Application Reference: 6/2021/1649/NMA

Proposal: Non-material amendment to change the shape of the turning head near Plot 6 and the erection of a gate to the property at Plot 6

Location: 36 The Ridgeway Cuffley Potters Bar EN6 4AX

<p>HFP Architects</p>	Client	CAVENDO HOMES	
	Job Title	CUFFLEY	
Chandos House Back Street Wendover Bucks HP22 6EB tel: 01296 625995 fax: 01296 622617 e-mail: info@hfparchitects.co.uk	Drawing Title	PROPOSED ACCESS GATES SITE PLAN	
	Date	June 22	Scale 1:250
	Job no	3356	
	Drawing No	PD401	Rev.

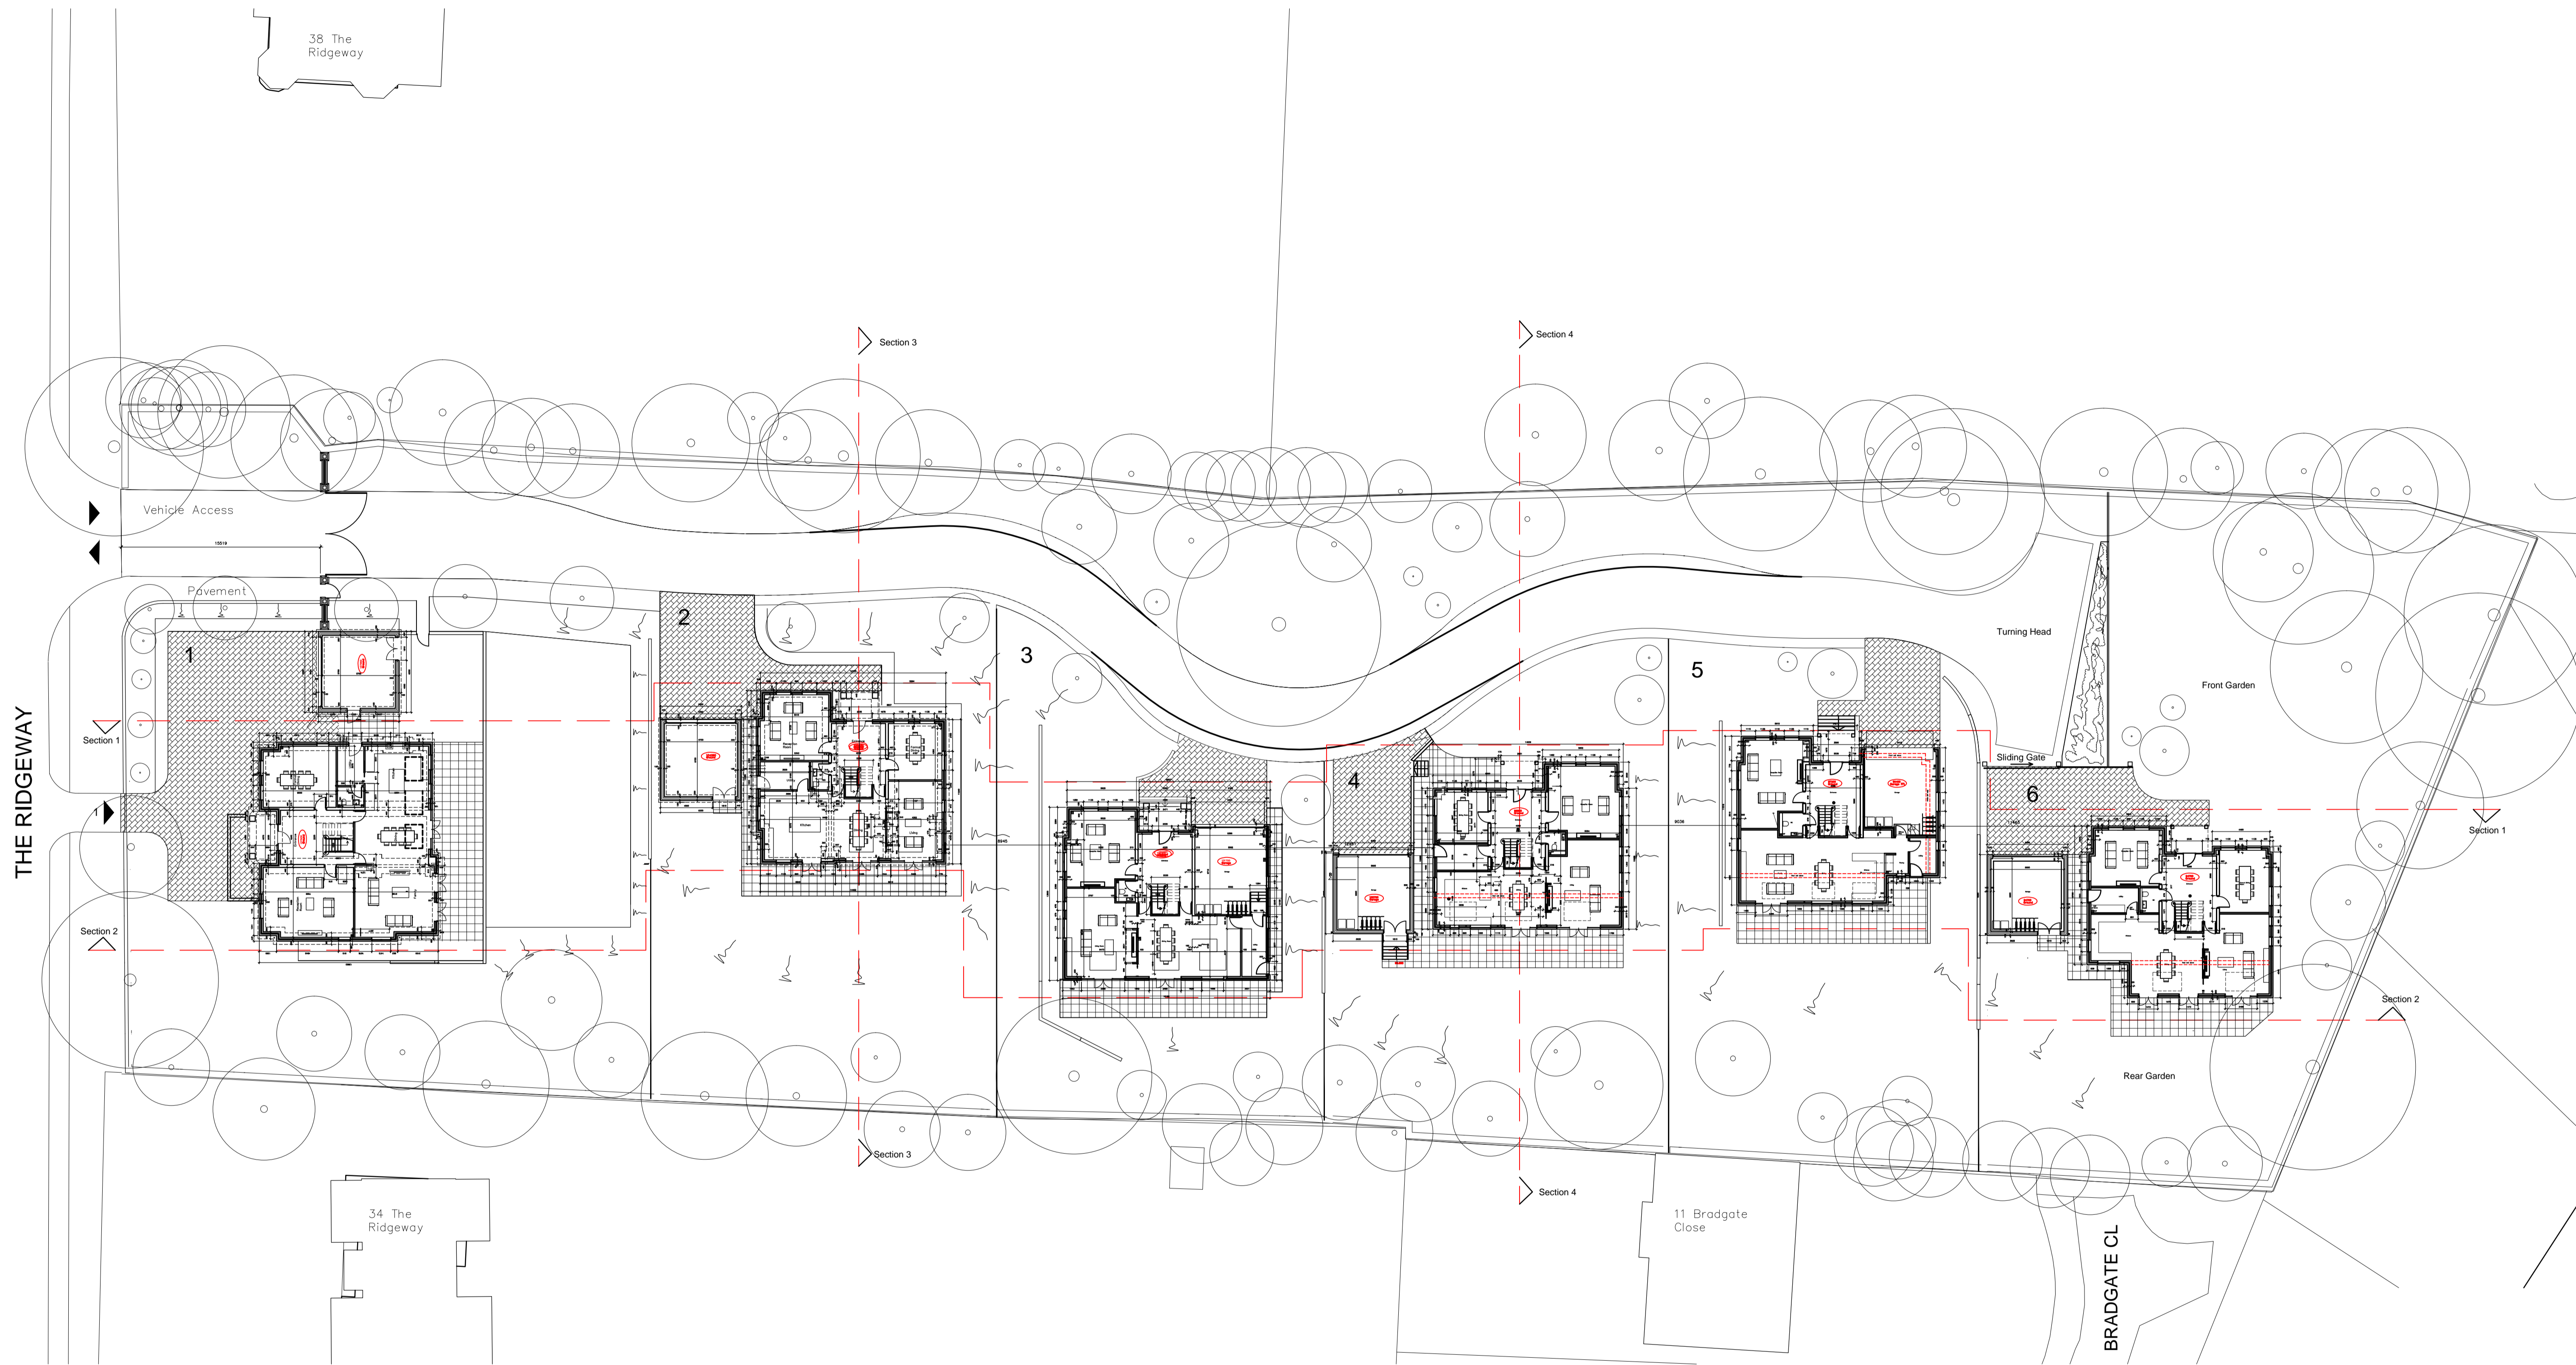
- Modification to the end of the internal road layout to change it to a hammerhead design with alterations to landscaping.
- Plot size of House 6 increased to accommodate additional land for front garden.
- Addition of a private sliding gate into the parking area of Plot 6.

The planning statement for this application states that the proposed revisions are not material to any development plan policies or conditions attached to the original planning permission, save for condition 22. However, this does not address the following two conditions:

The proposed amendments may have a material effect on the quality of the approved development and highway safety due to the changes to the design and layout, as well as result in conflicts with the approved conditions. Additional information was requested on 11th October 2022 (including a landscaping plan) to allow these matters to be fully considered. Further follow-up requests were then made on 24th October 2022 and 10th November 2022 as the information had still not been provided. As I am not in receipt of this information, I am unable to conclude that the proposed works would be non-material and subsequently this application is refused. A new non-material amendment application which includes the required information, a new planning application or a variation of condition of the original application would therefore be required if your clients wish to pursue the amended scheme.
